Department of Planning and Environment

Our ref: SSD-35538829

Subject: Response to Submissions - Addendum

I refer to State Significant Development application SSD-35538829 for the Parramatta Over and Adjacent Station Development. After careful consideration, the Department requests that you provide the following additional information:

Figure 11 Viewpoints
Source: Virtual Ideas

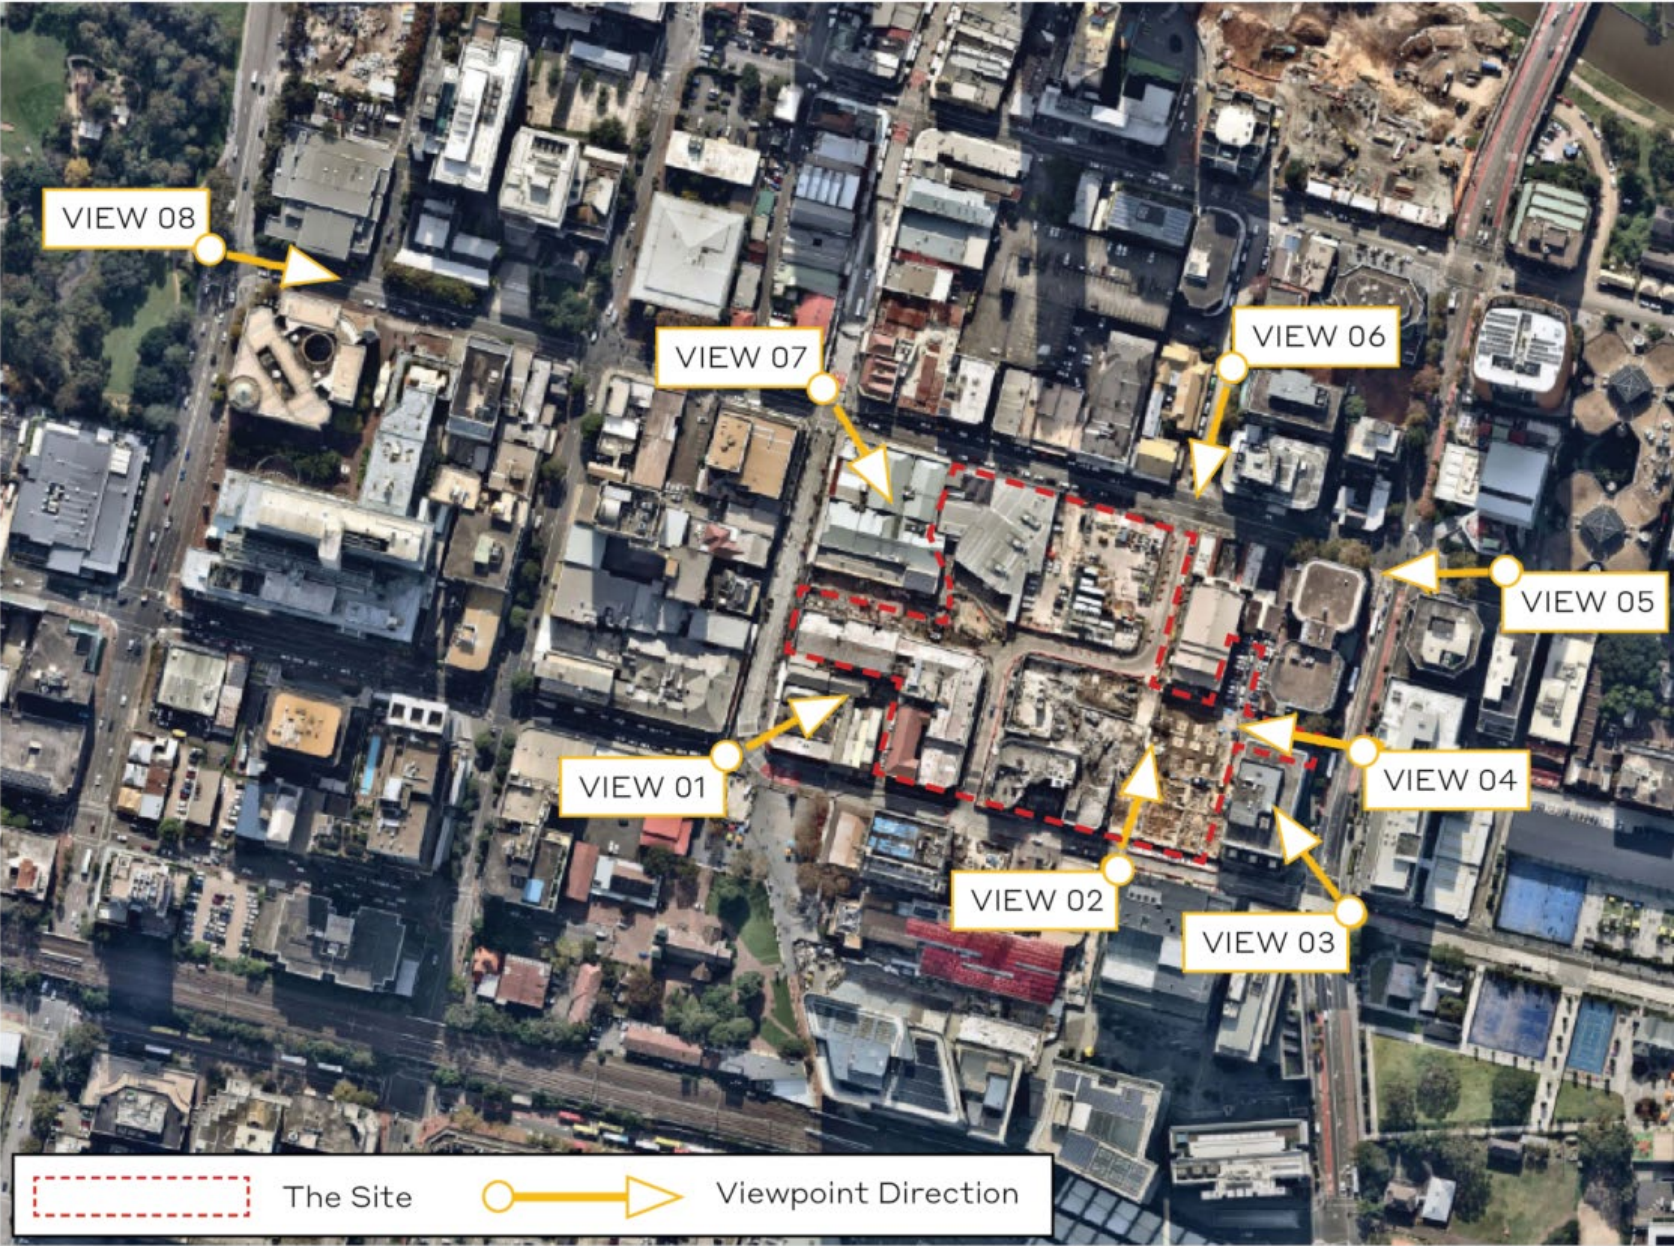
- c. Revise the Visual Impact Assessment for the viewpoint at the south-east corner of Macquarie Street and Smith Street (Viewpoint 3) to consider the educational use and any heritage item and open space at this location.
